Suffolk County Council (20041323)

Comments on any other submissions
received at Deadline 6

Bramford to Twinstead (EN020002)

17 January 2024

Figure 2.1 – PRoW Closures >1 day in Q1 2025 (Indicative Date)

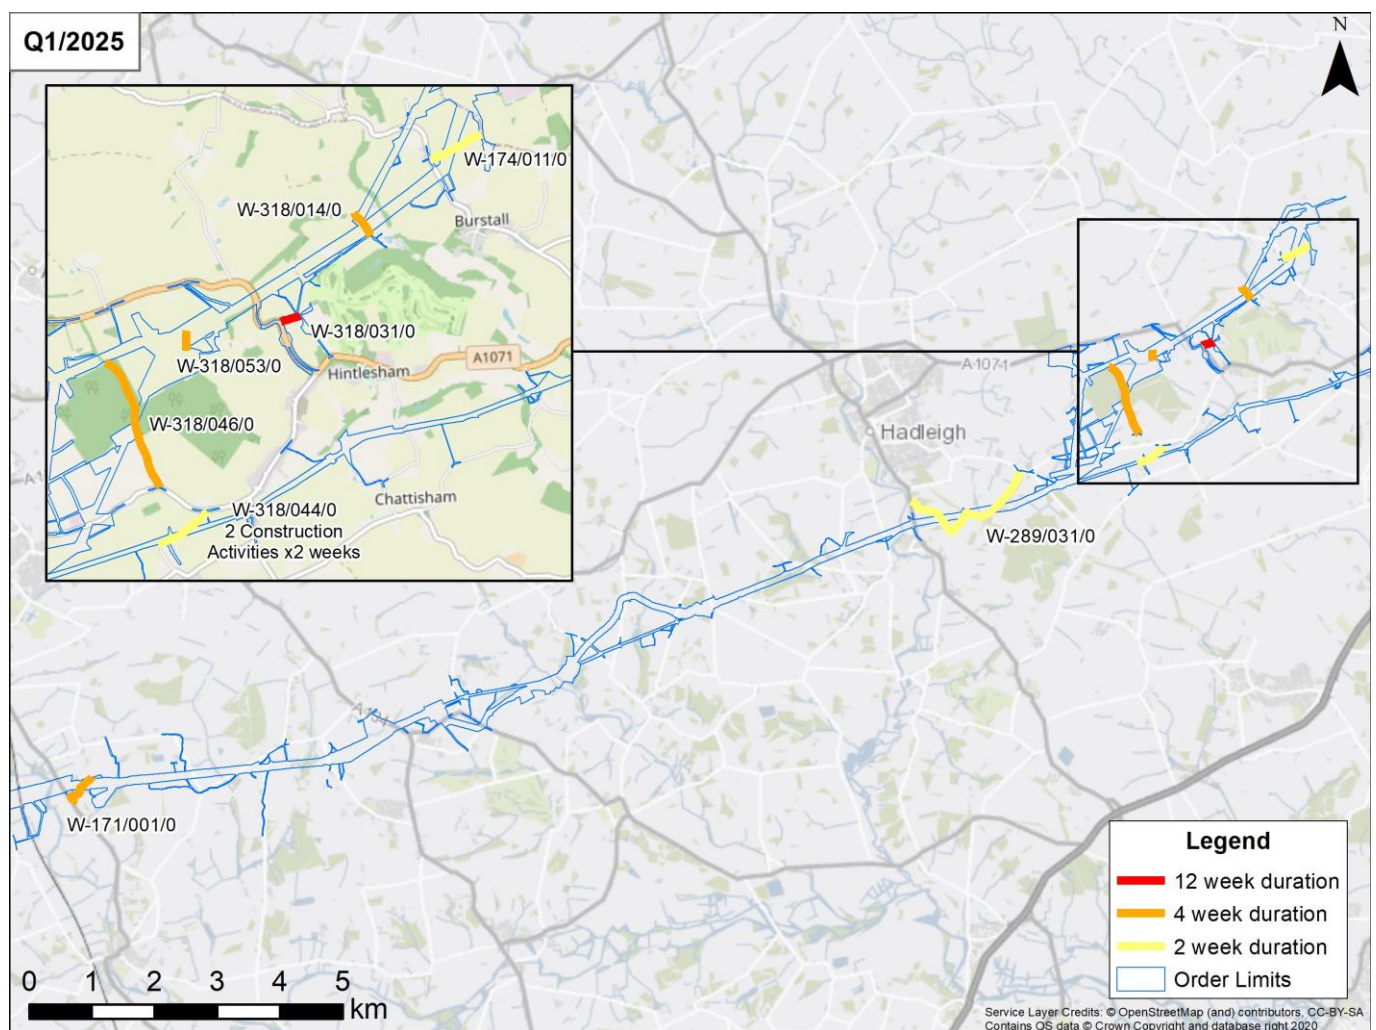
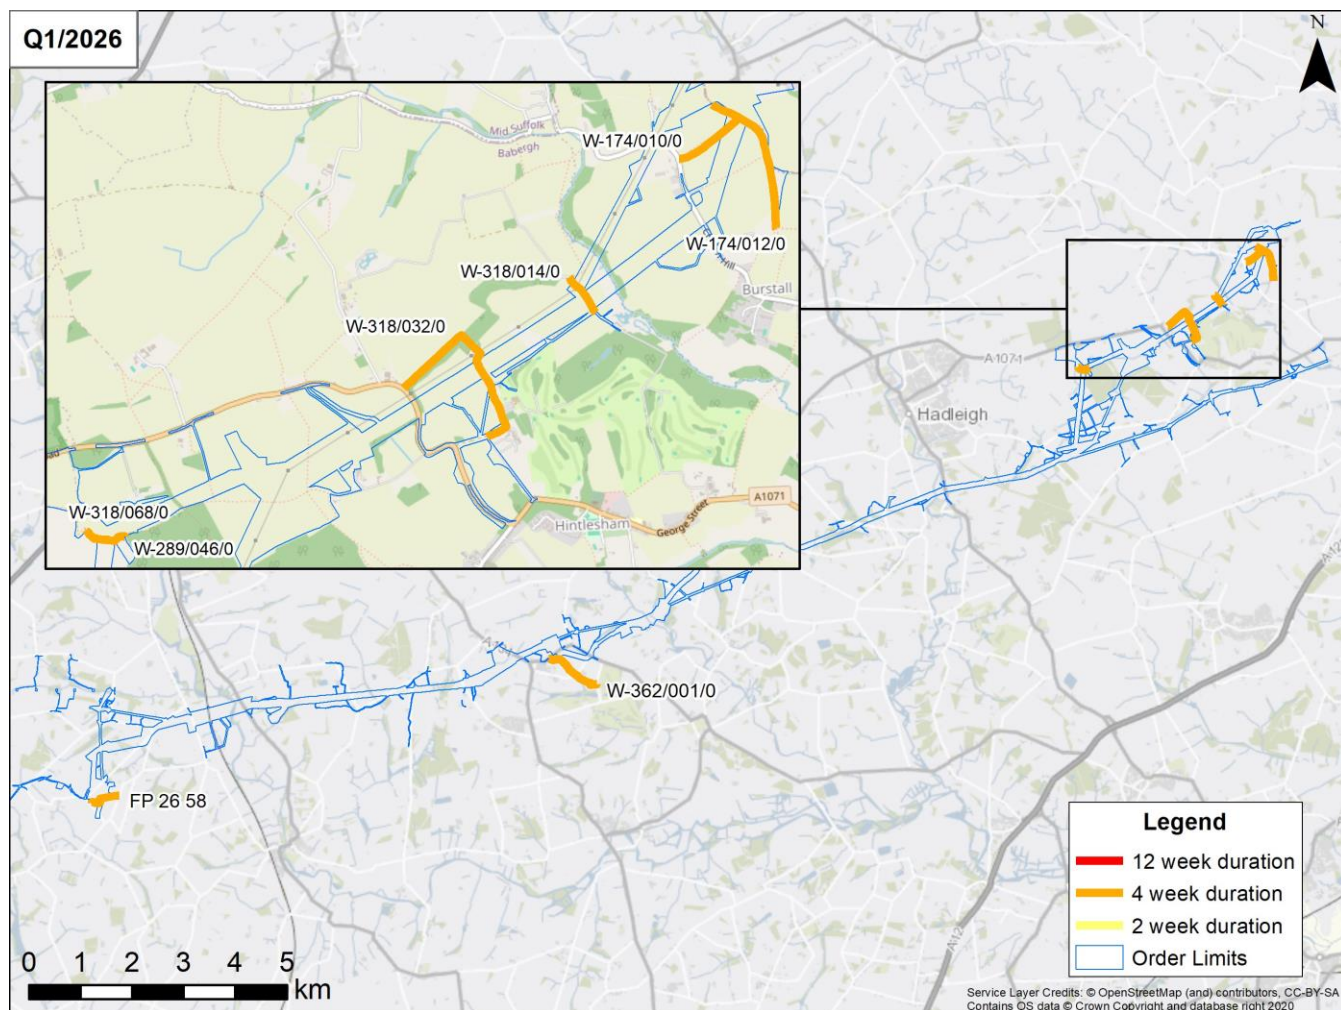
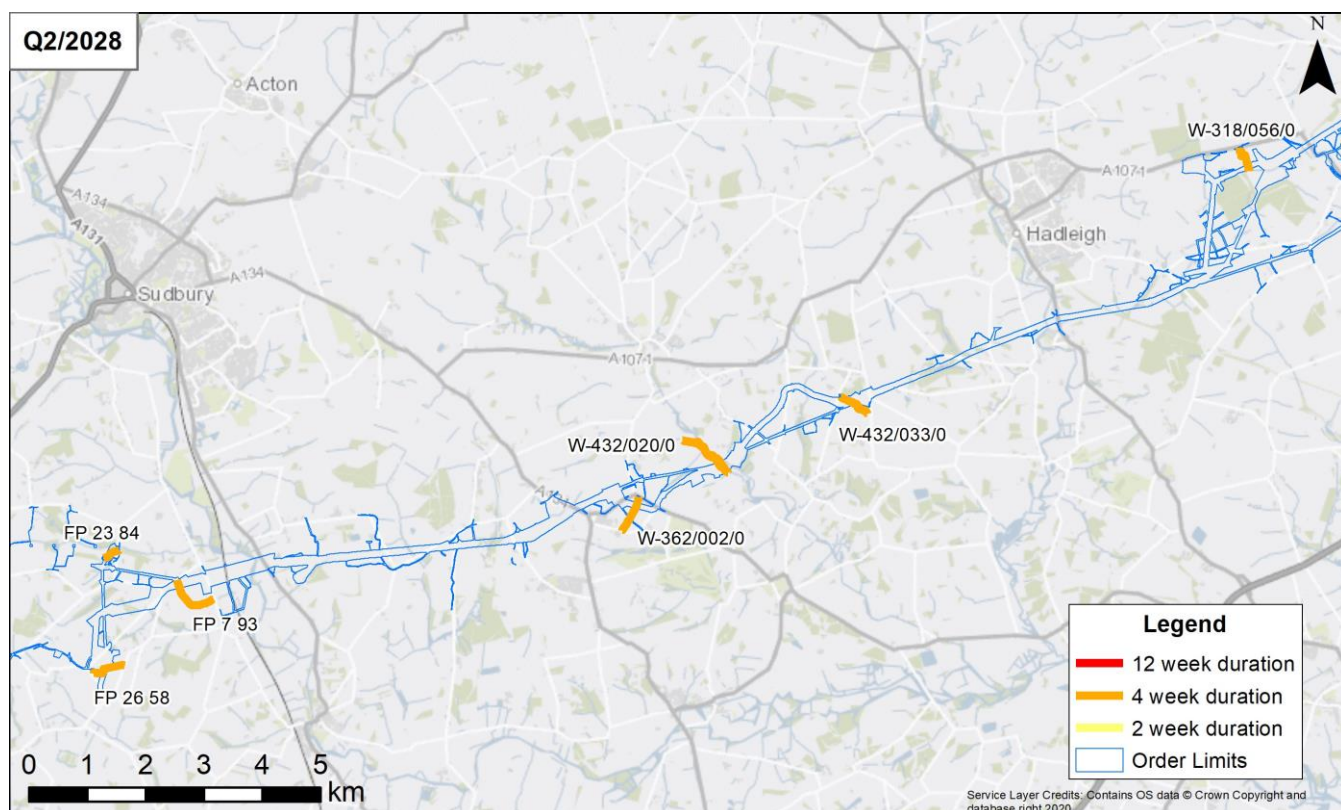
Table 7: SCC Table of Comments on the Technical Note on PROW Closure Sequencing [REP6-049]				
Ref	Topic	Ref No.	Summary of Comments	SCC's Comments
7a	Technical note on Public Rights of Way closure sequencing	8.8.9		<p>SCC (PROW) welcomes the inclusion of closure sequencing of the Public Rights of Way network.</p> <p>The information provided confirms which routes will be affected in conjunction with adjacent parts of the network.</p> <p>The technical note provides adequate information on the phasing of network restrictions. Assessment will be undertaken of the cumulative effect of the closure of the routes and provided at deadline 8.</p>
